Outline Planning Application Amendments: PR9 21/03522/OUT

OS Parcel 3673 Adjoining And West Of 161 Rutten Lane Yarnton OX5 1LT Cross Parish Boundary Application: Begbroke and Yarnton Parish Councils

Comments from Yarnton Parish Council

FIGURE 21 - LAND USE PLAN

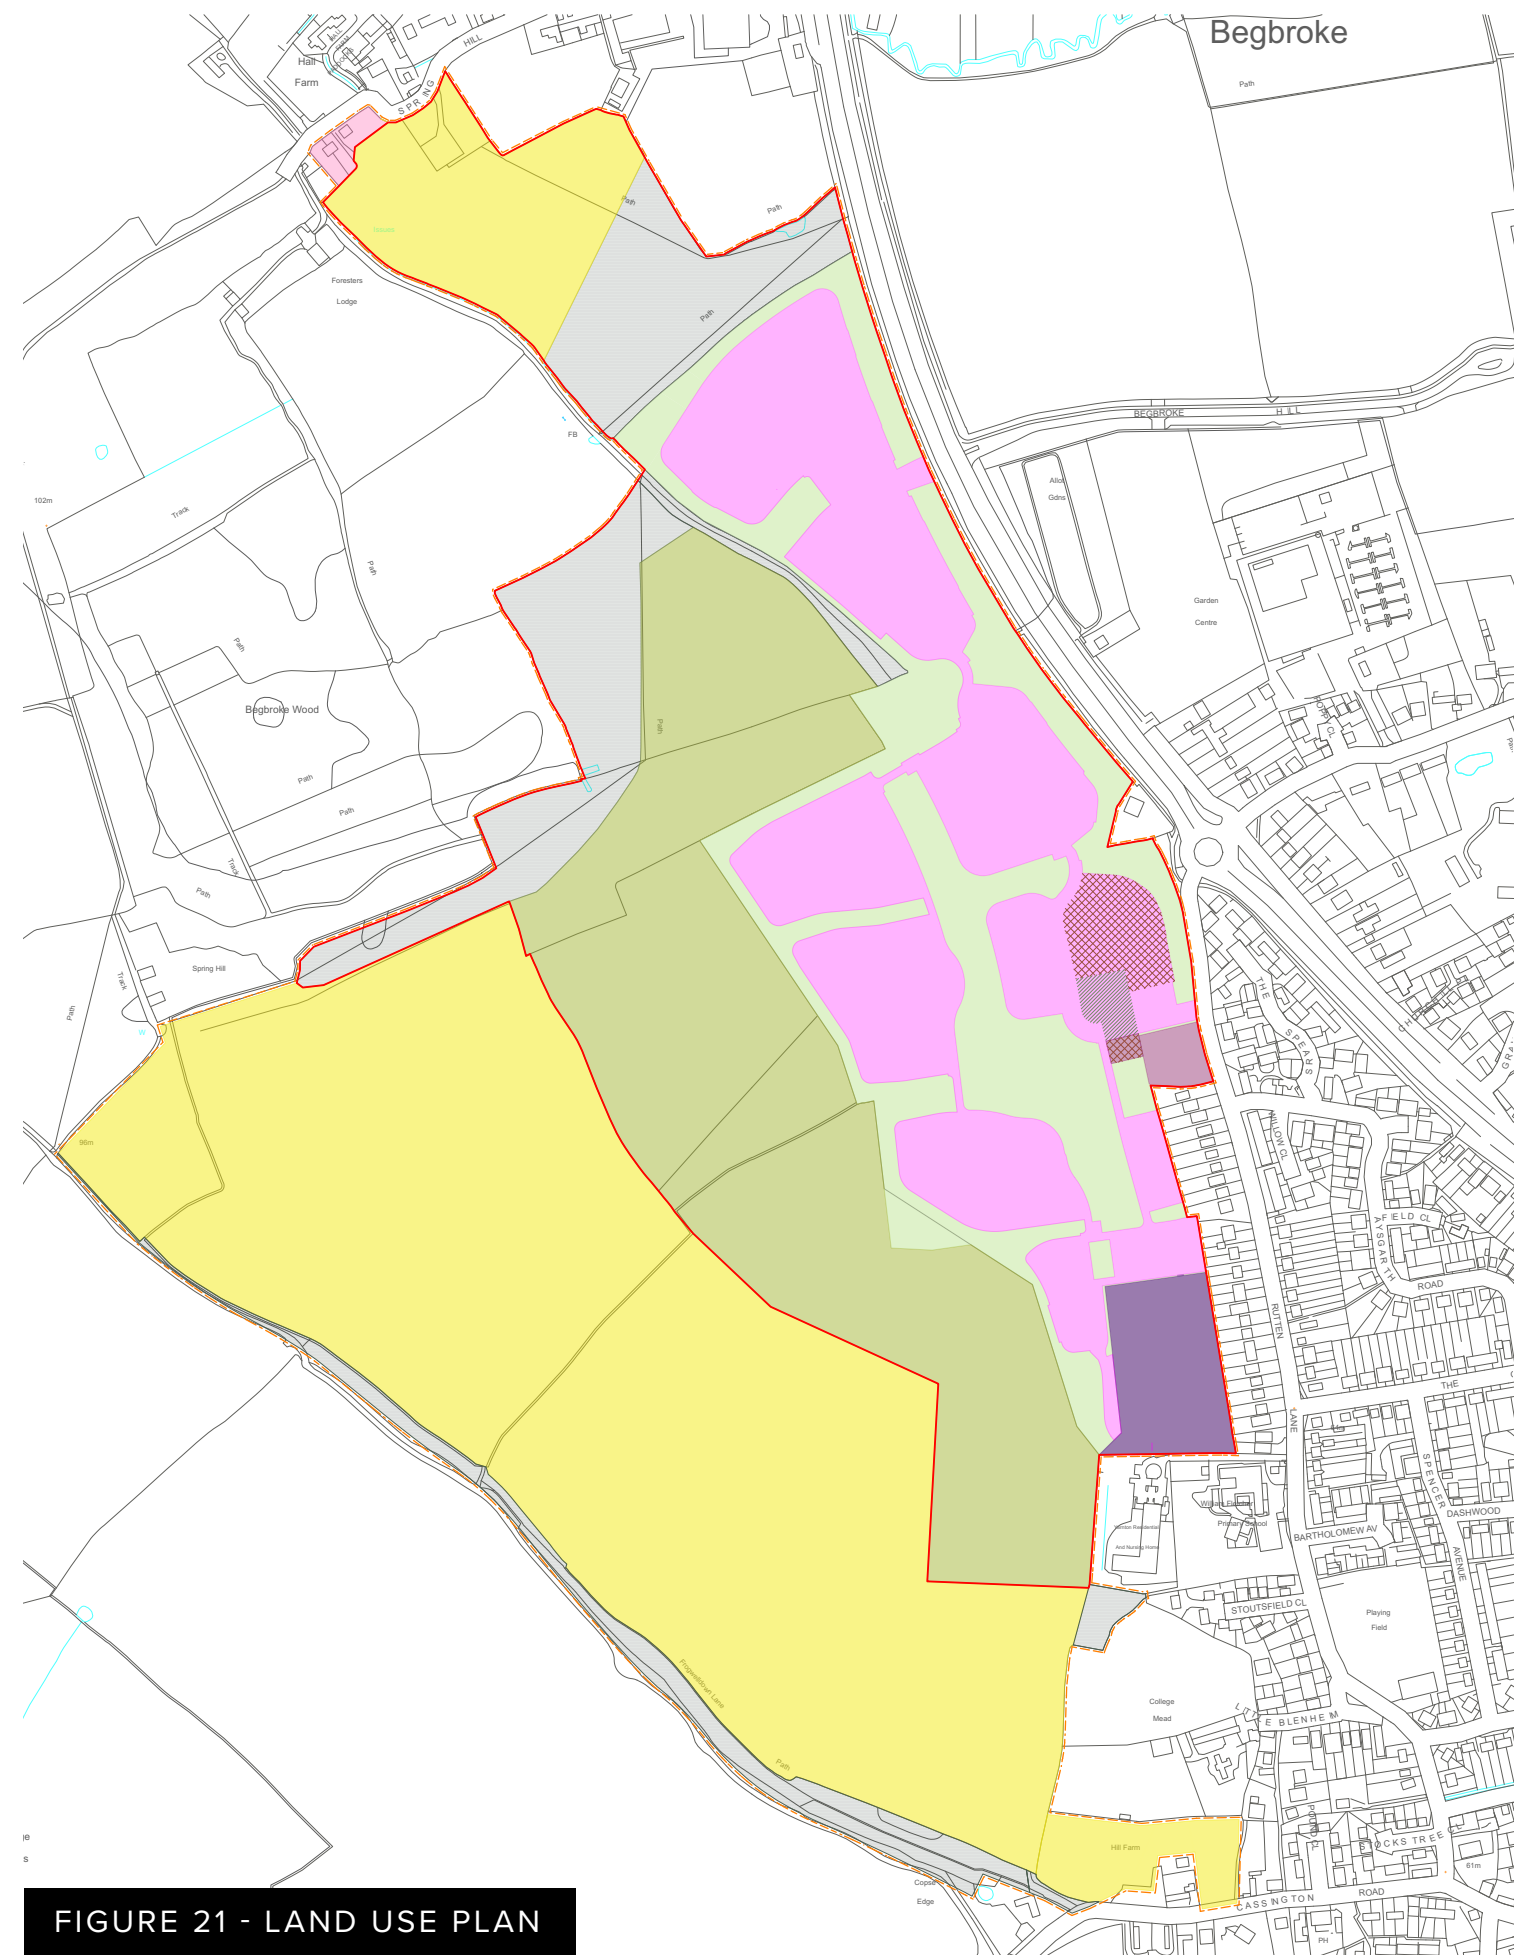
Fig 21 of DAS does not appear to show proposed new southbound bus stop in Rutten Lane near to the site access point and medical practice. Has this been dropped from the plan?
